SCOPING OPINION:

Proposed Ray II Wind Farm

Case Reference: EN0110031

16 June 2026

Figure 8.1b
Relevant Designated Sites within the Grid Connection Study Area

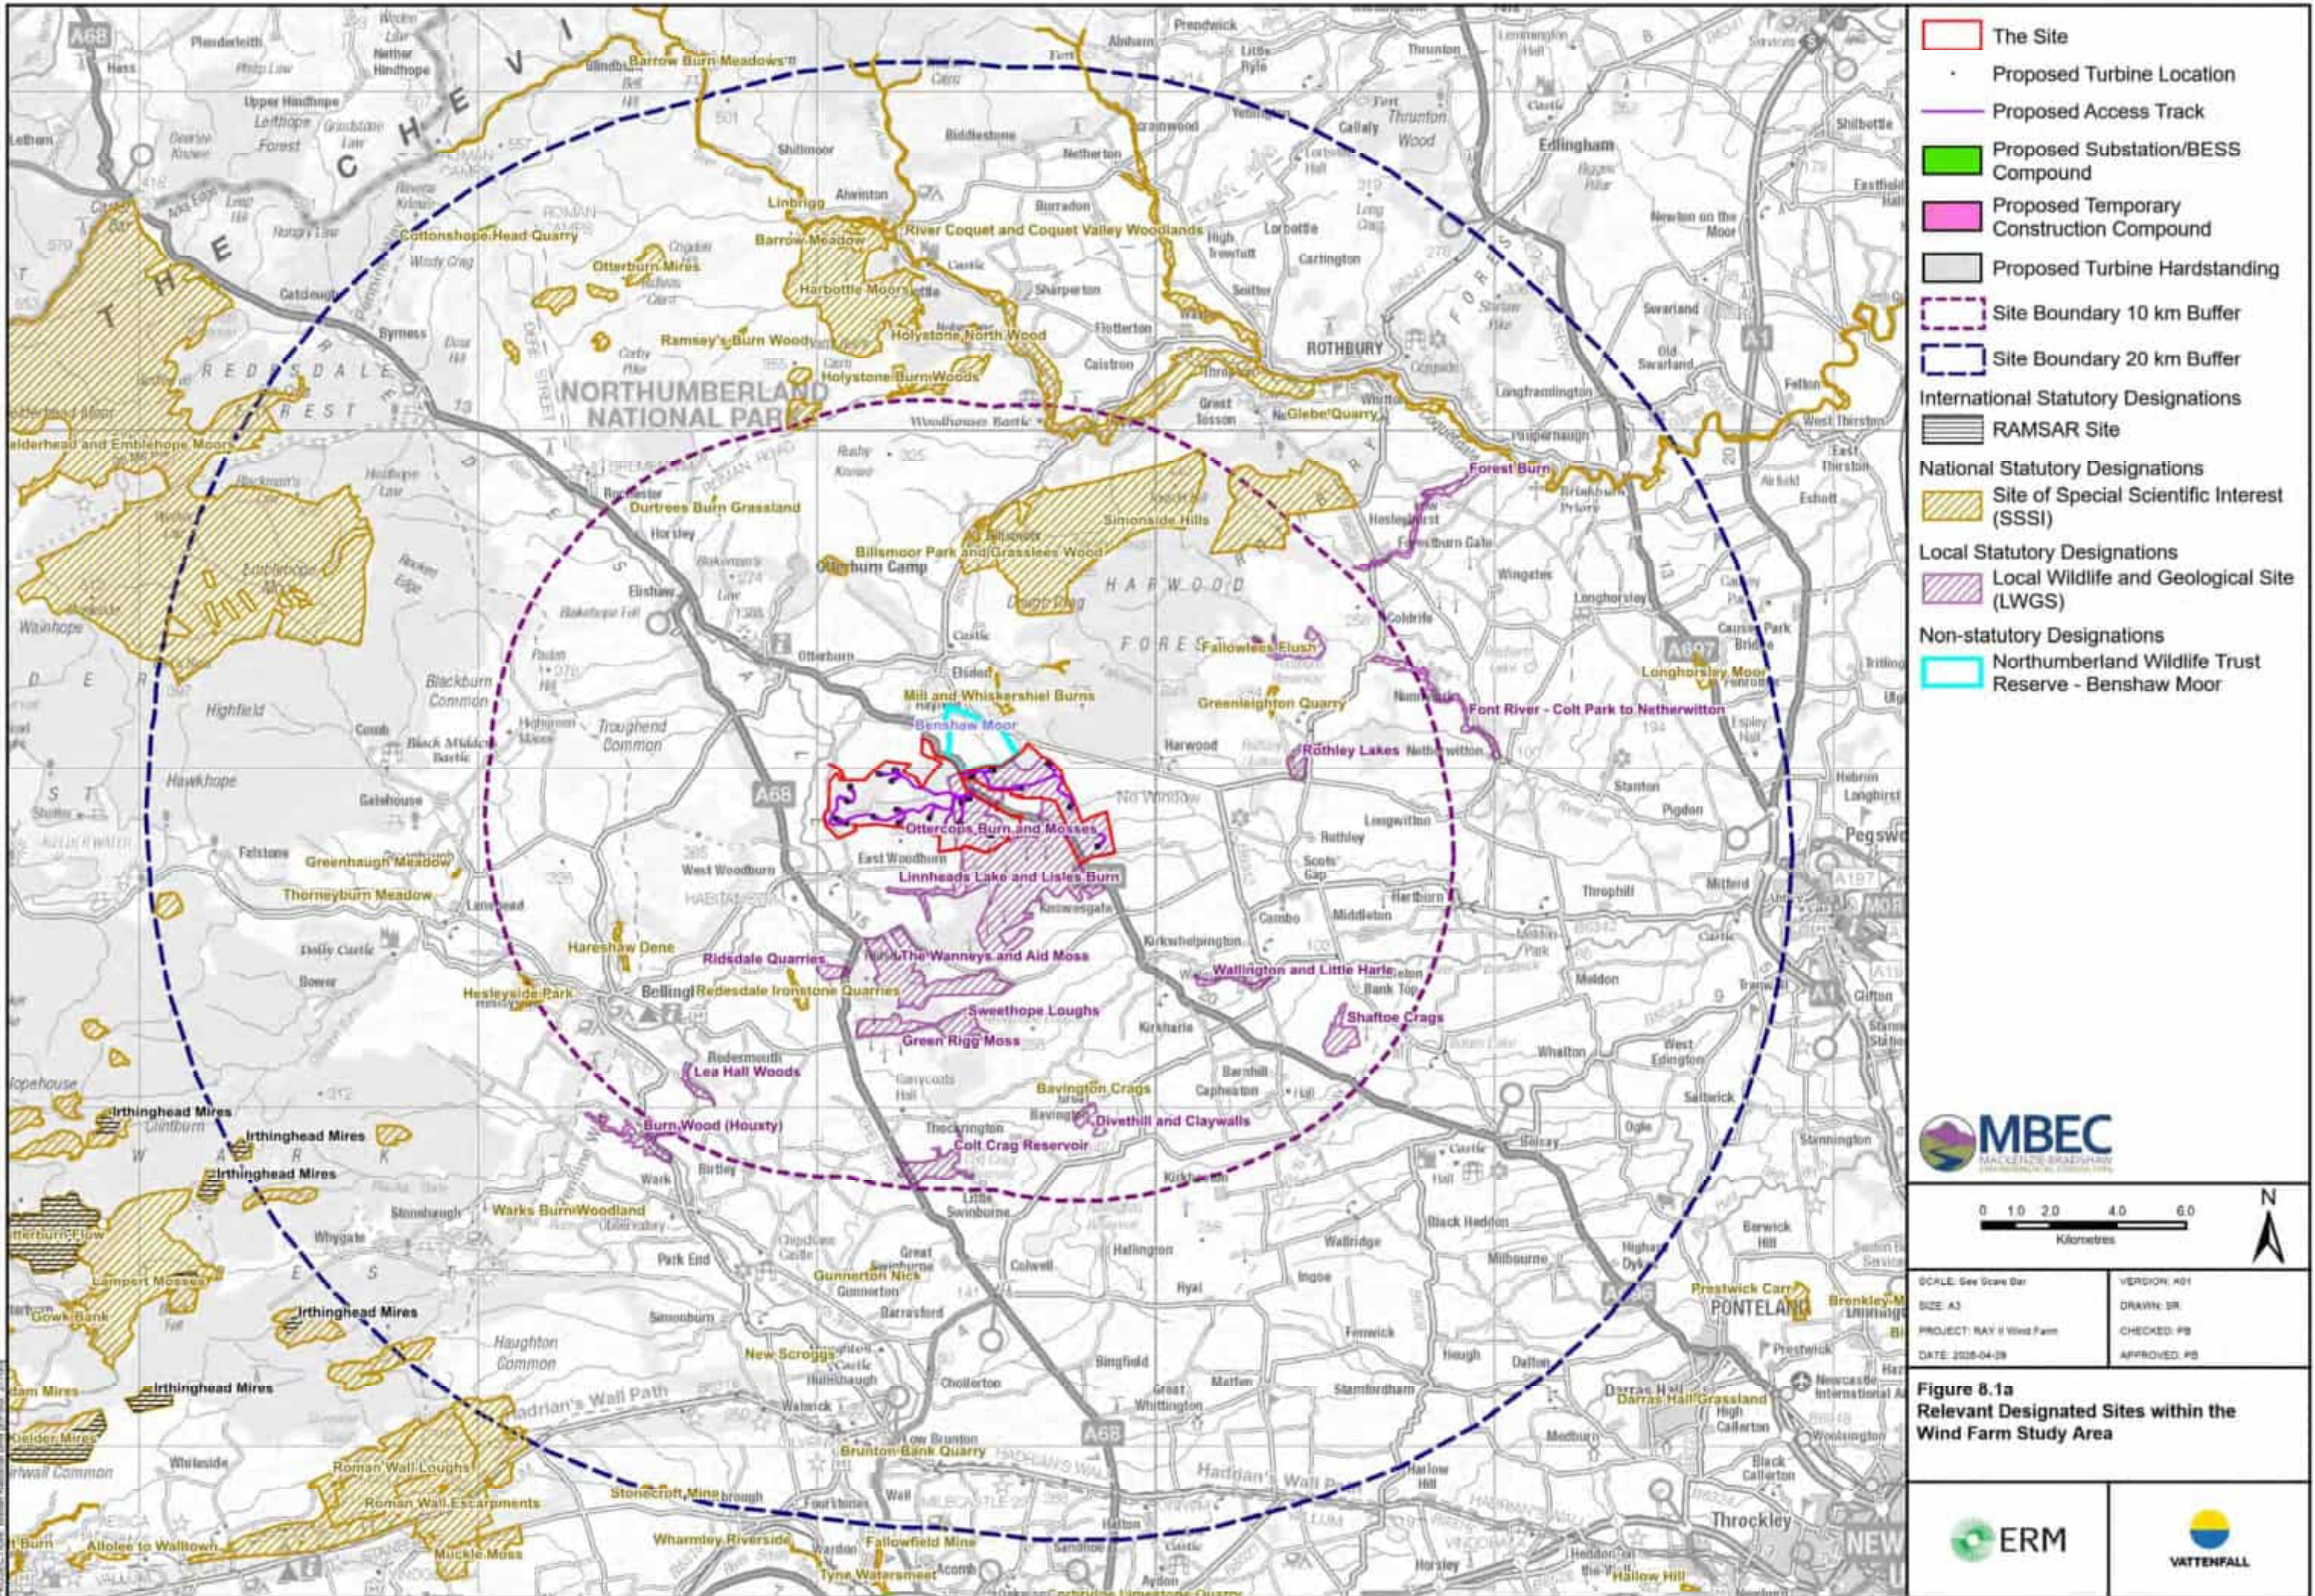
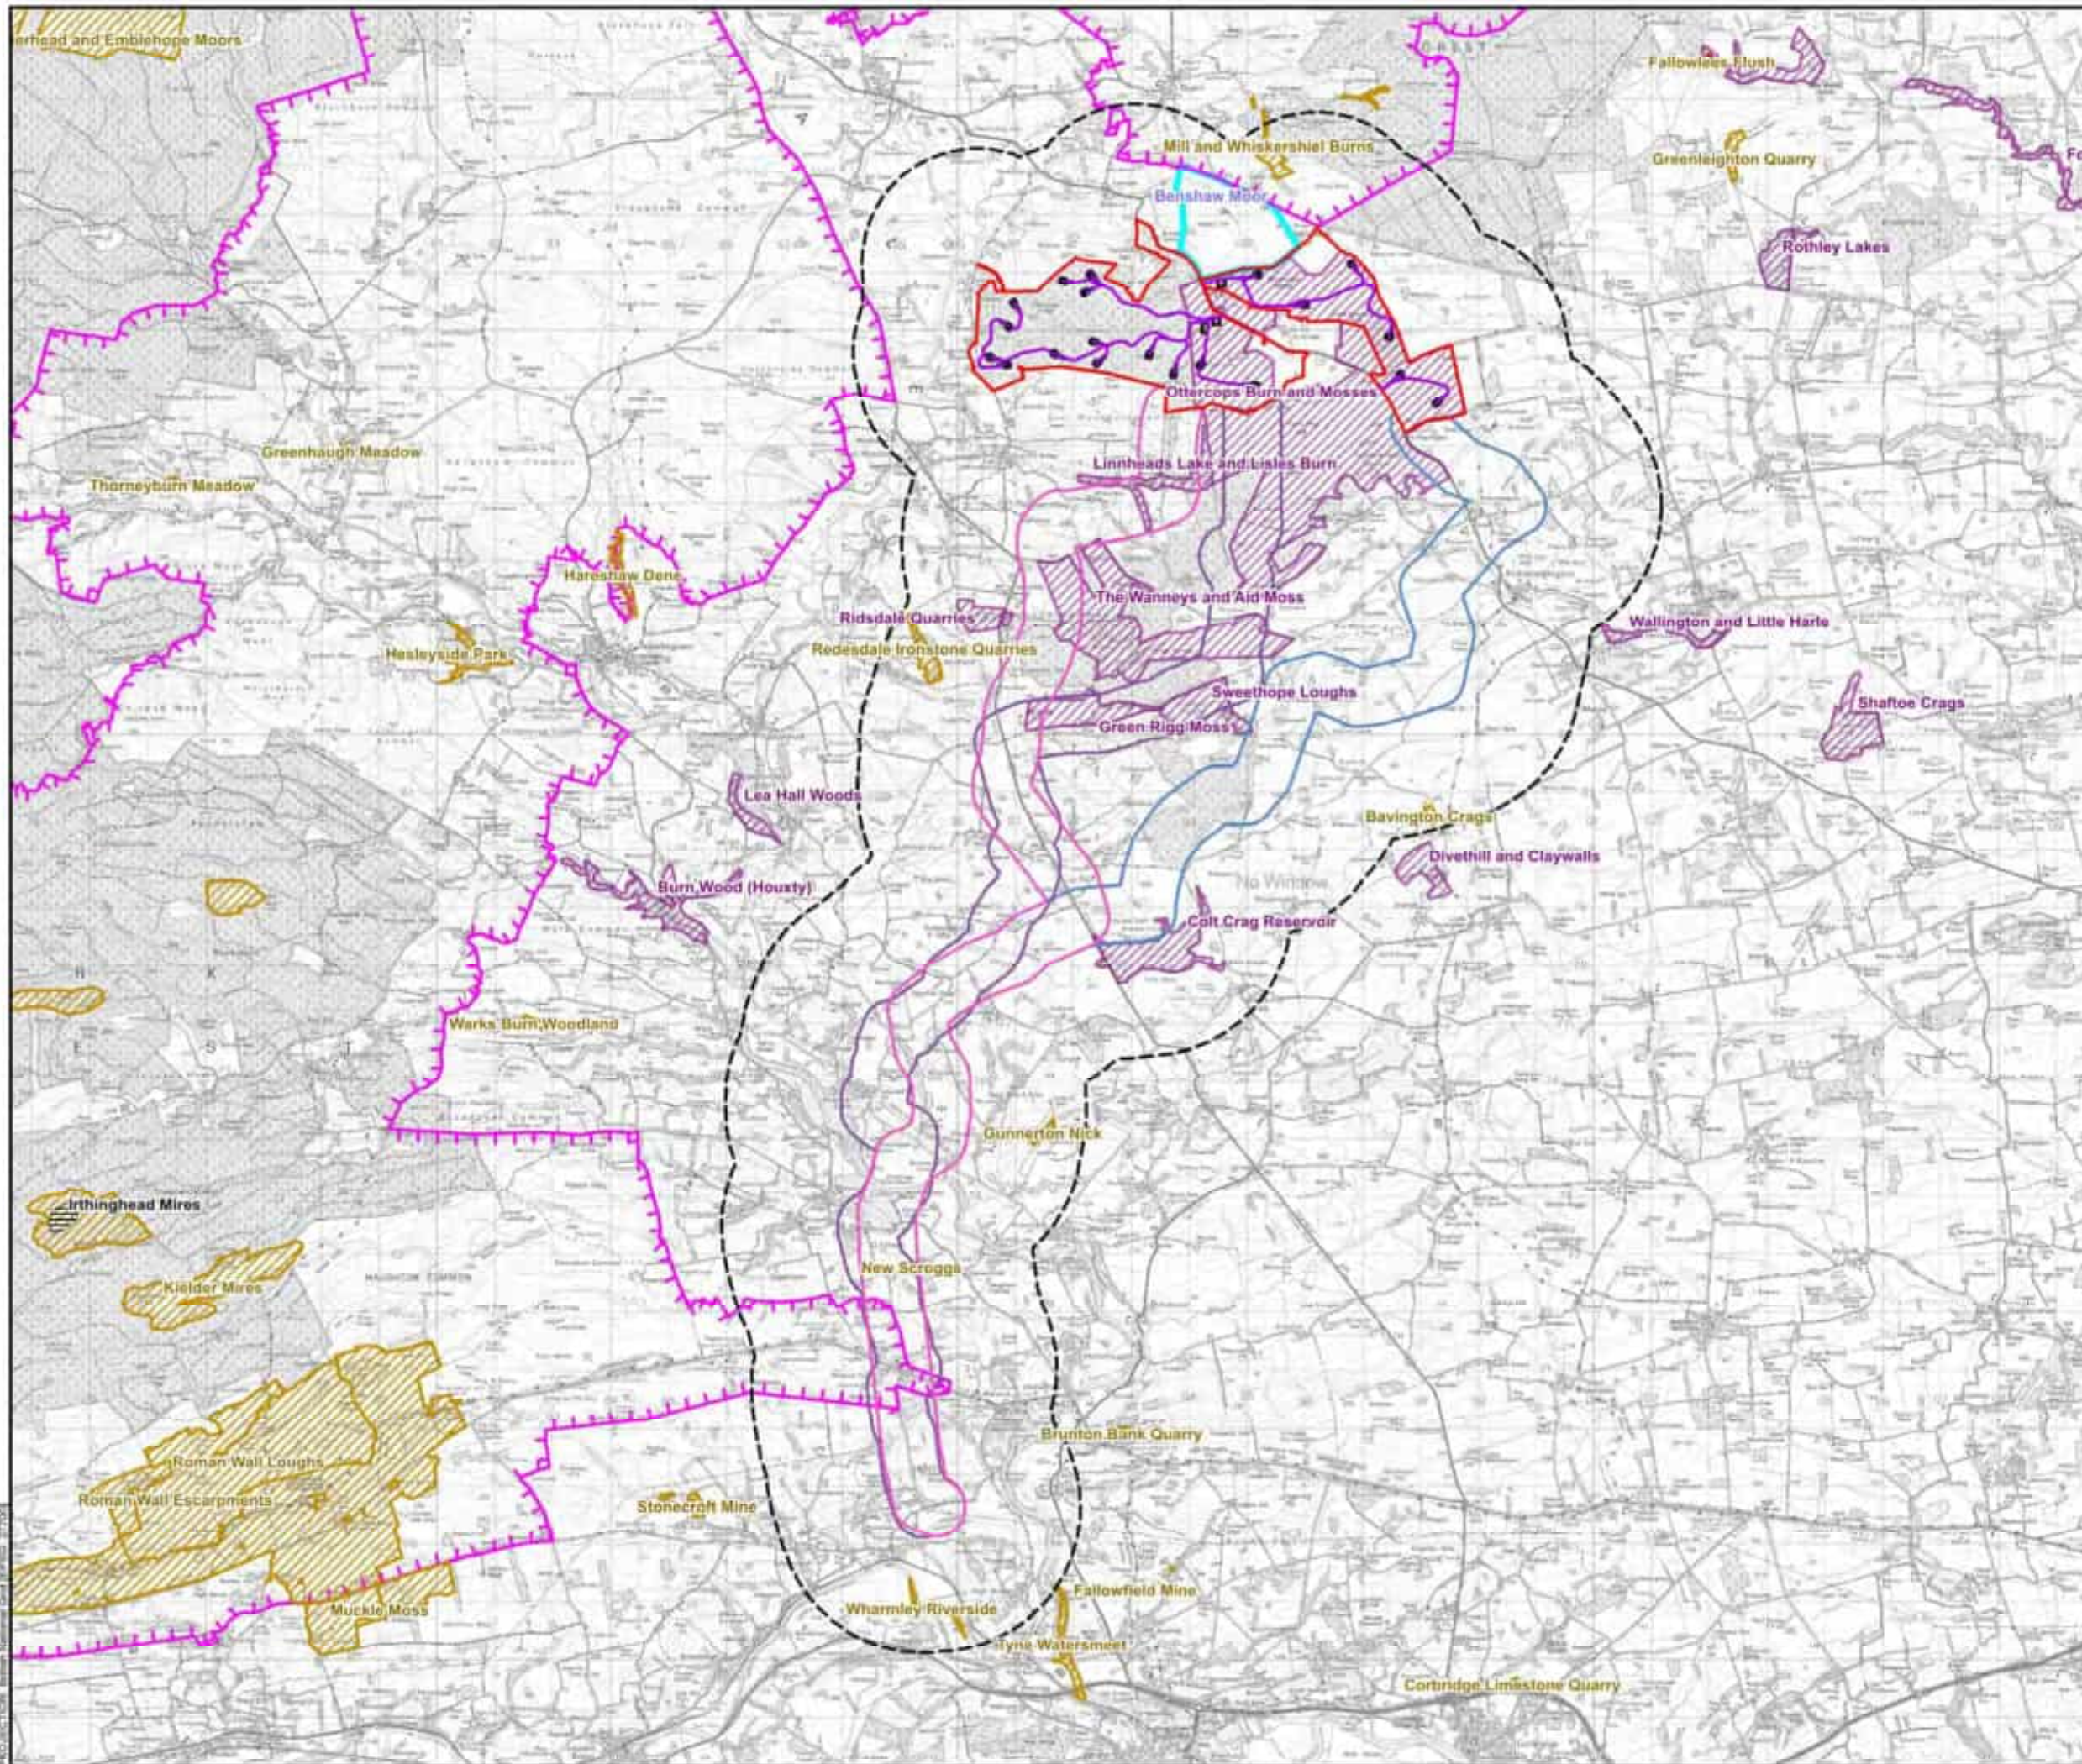
ID	Ref	Description	Inspectorate's comments
334	Paragraphs 8.3.1 and 8.3.2.1 and figures 8.1a and 8.1b.	Study area – statutory designated sites	The Scoping Report states that the desk study area for designated sites extends to 30km for the turbine area "the site" and to 5km for the cable corridor options. It is stated that this is based upon the connectivity of bird species in SPAs. However, the buffer shown in Figure 8.1a only extends out to 20km. The buffer shown in Figure 8.1b also only extends out to 2km from the cable corridor options. The ES should ensure that figures which are provided to support the main text should be consistent. As it is not yet known whether the grid connection will be underground or via an overhead line, the Inspectorate considers that the ES should include a wider study area of at least
